As discussed in the meeting with staff, address in memo the following bullets:

COLORADO KIDS
RANCH SITE
DEVELOPMENT PLAN

COLORADO KIDS RANCH
18065 SADDLEWOOD ROAD, MONUMENT, CO 80132

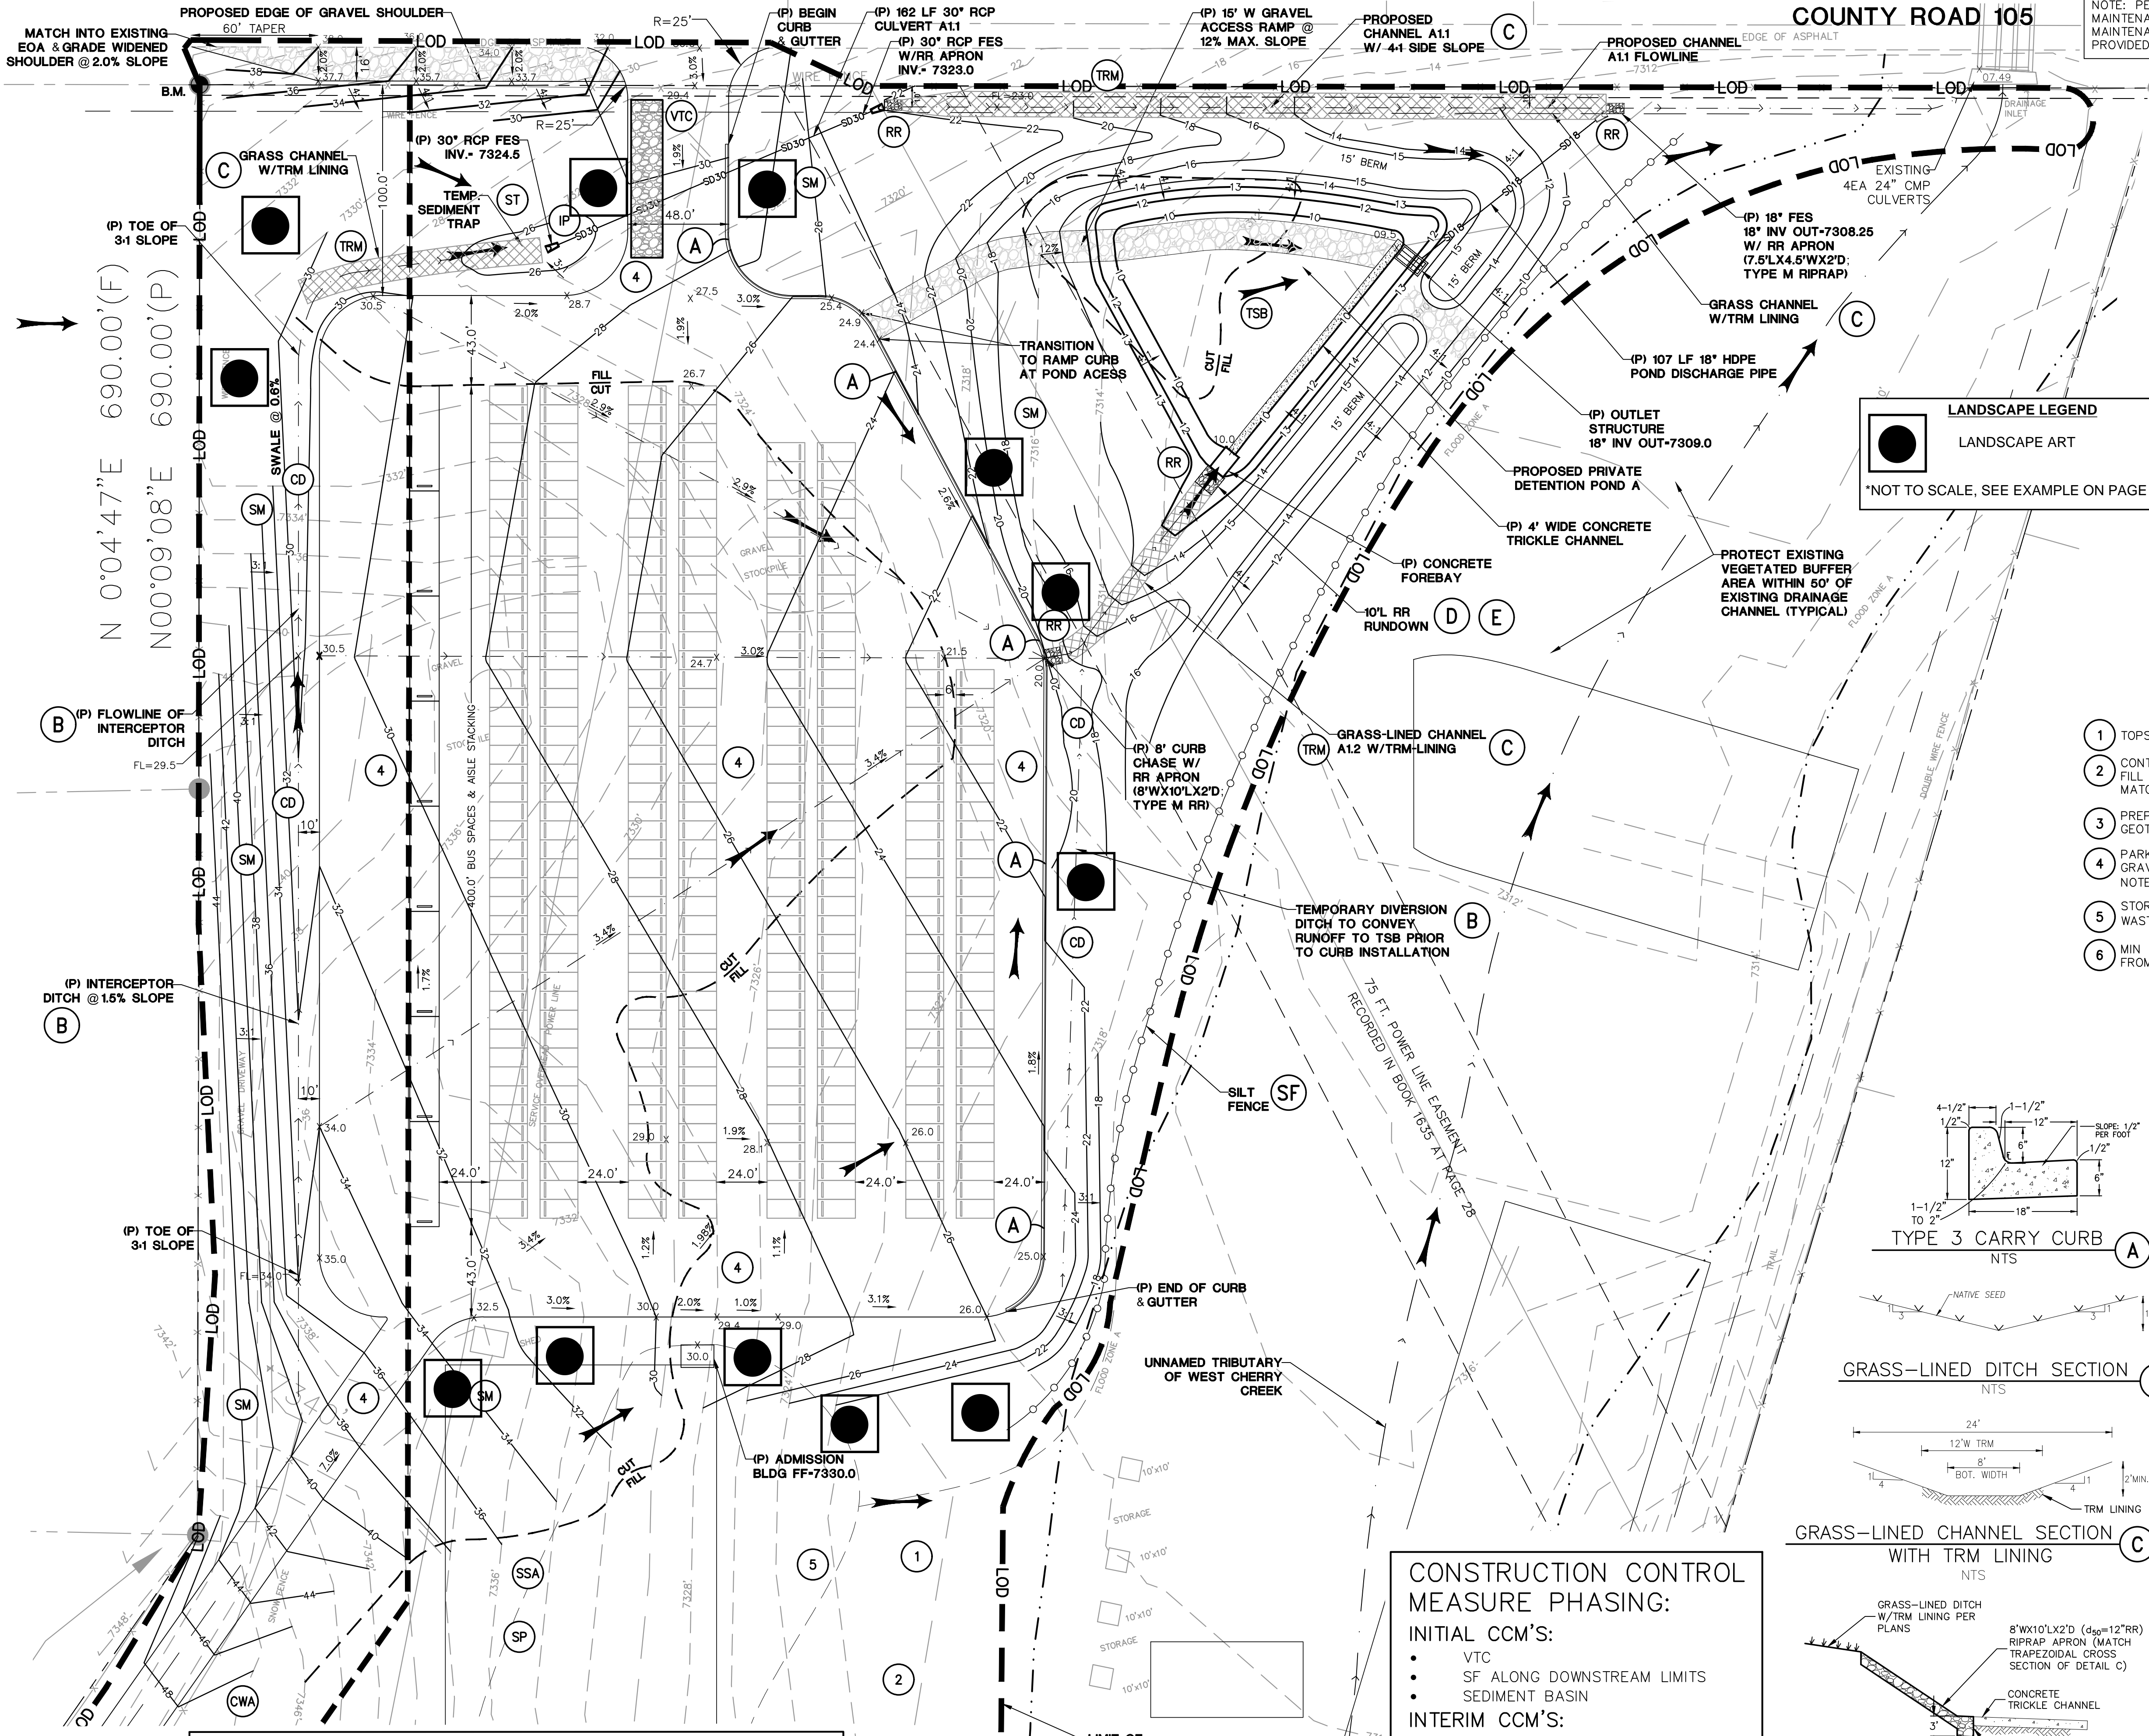
Update to show how access is going to tie into HWY 105 and provide cross section for access point. Label ingress and egress lanes and shoulders.

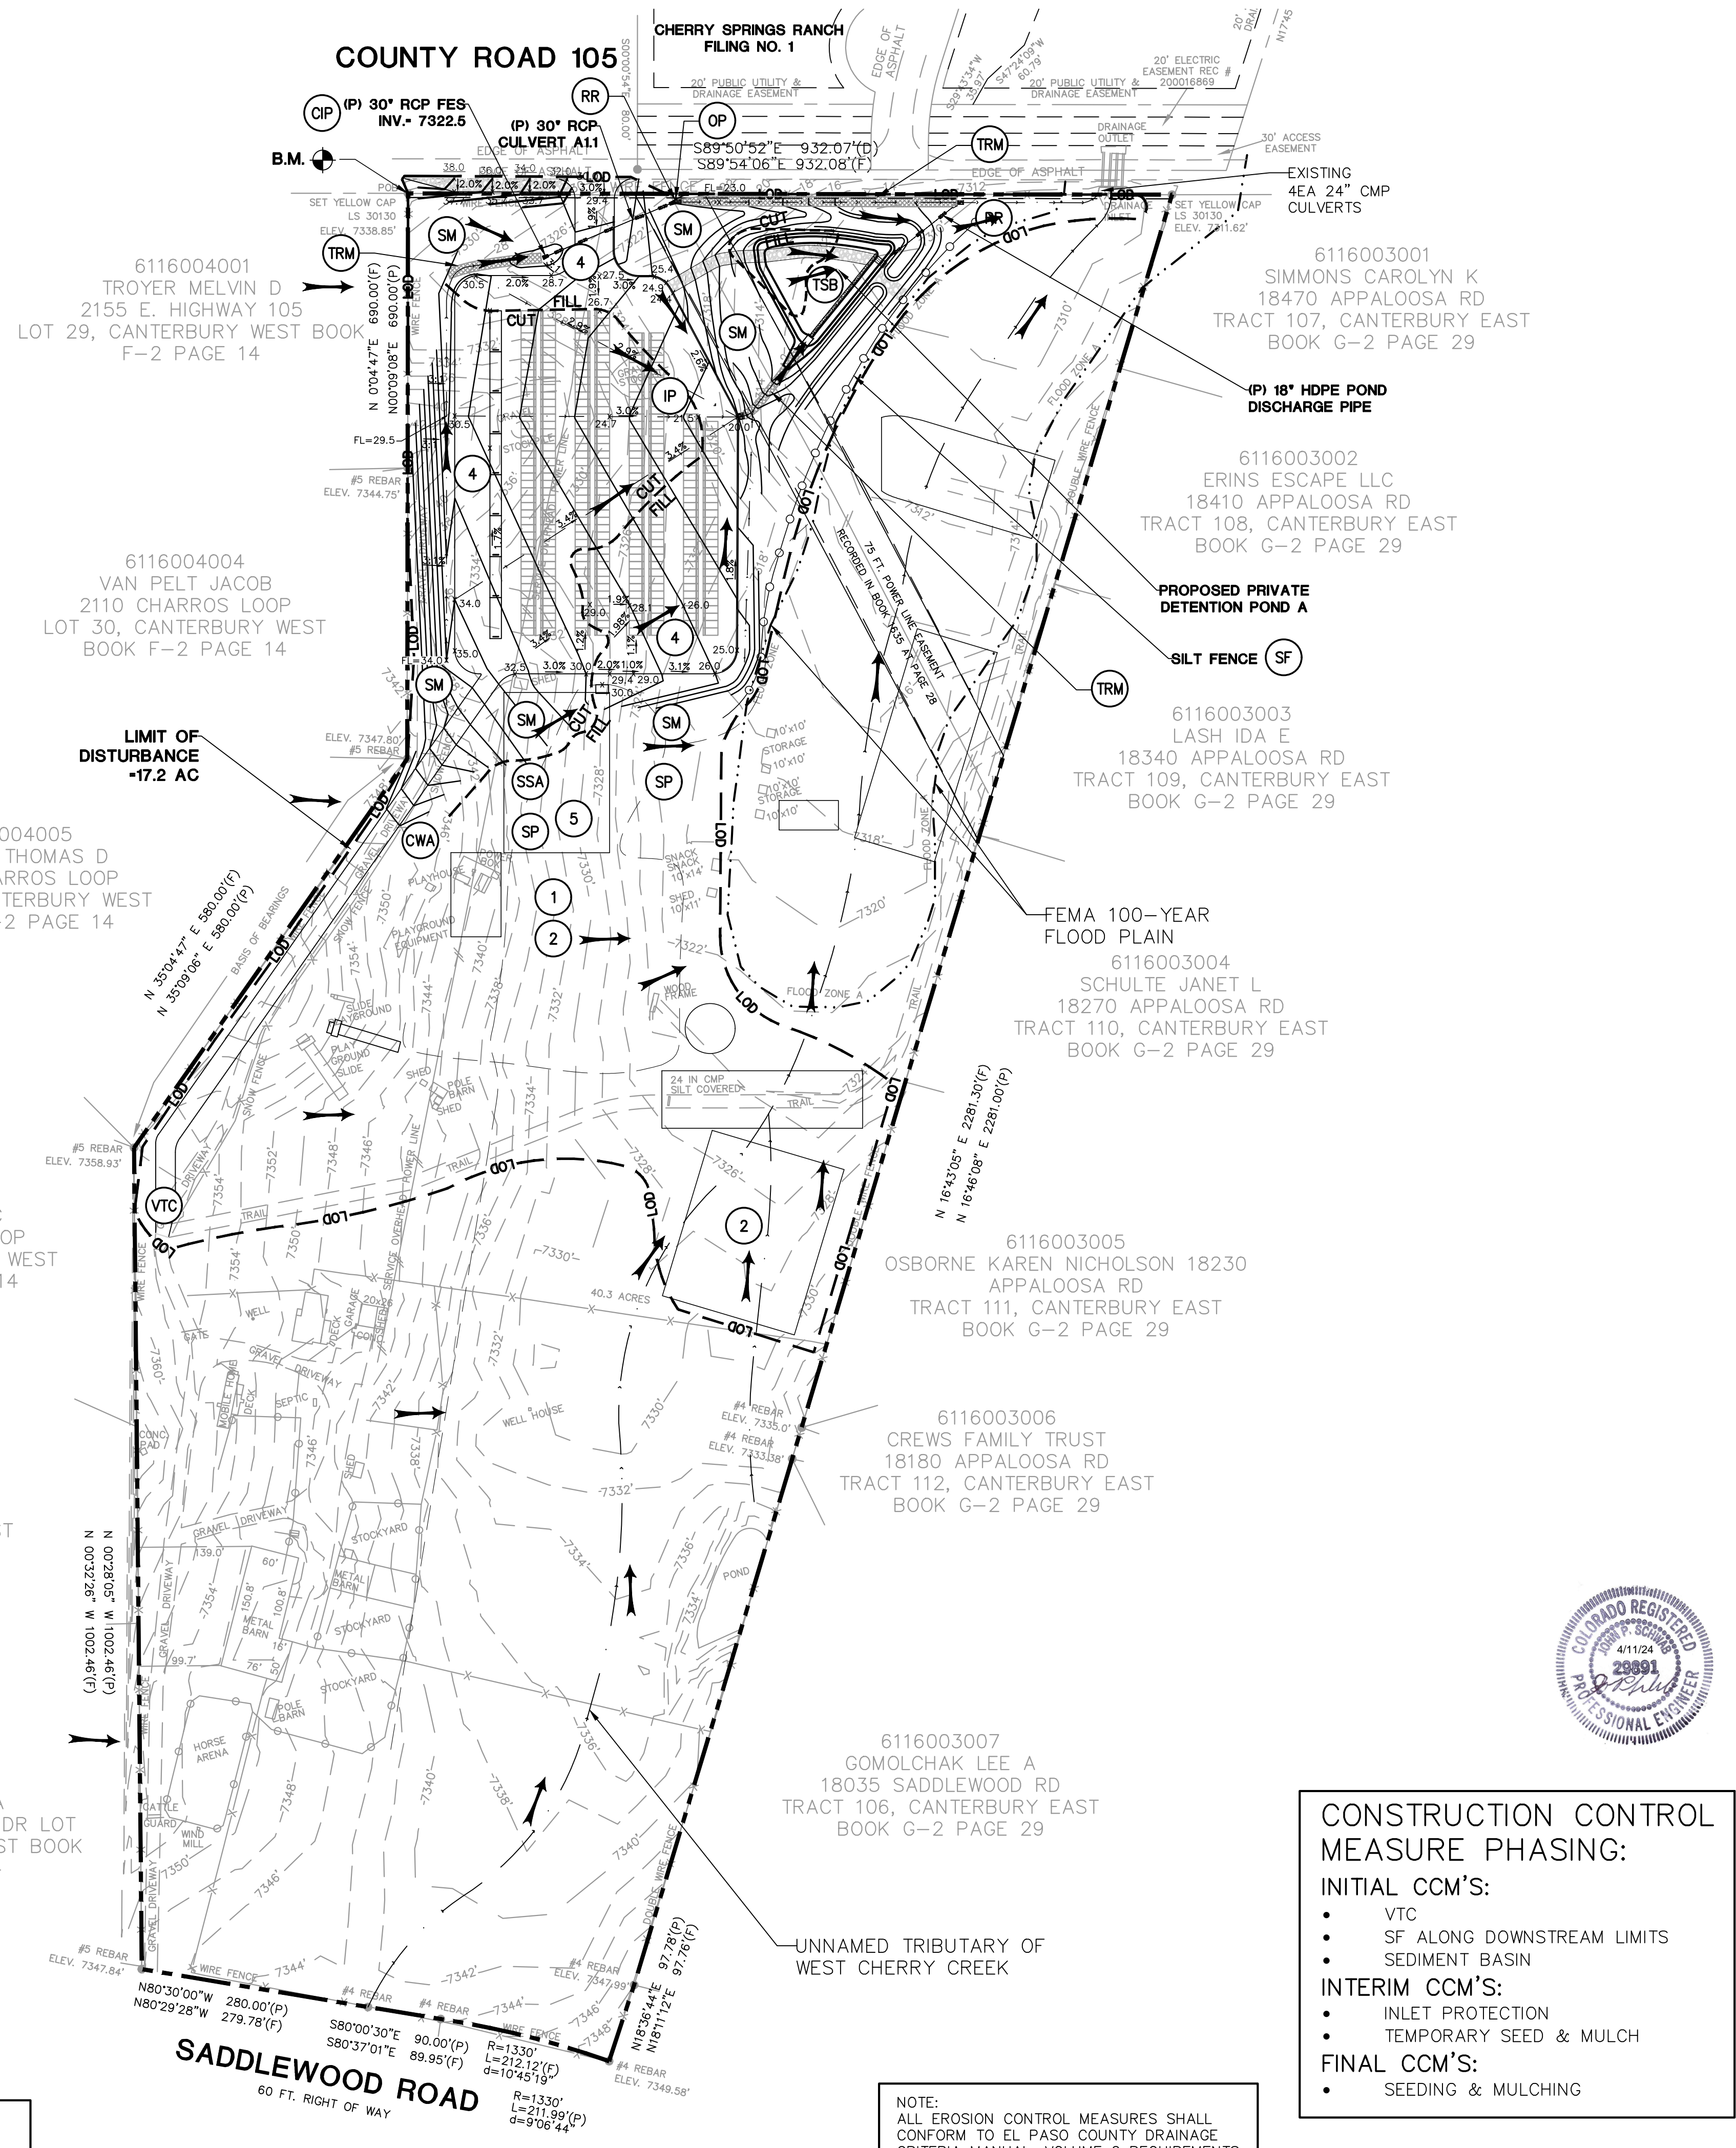
Update to show gate for temporary access point.
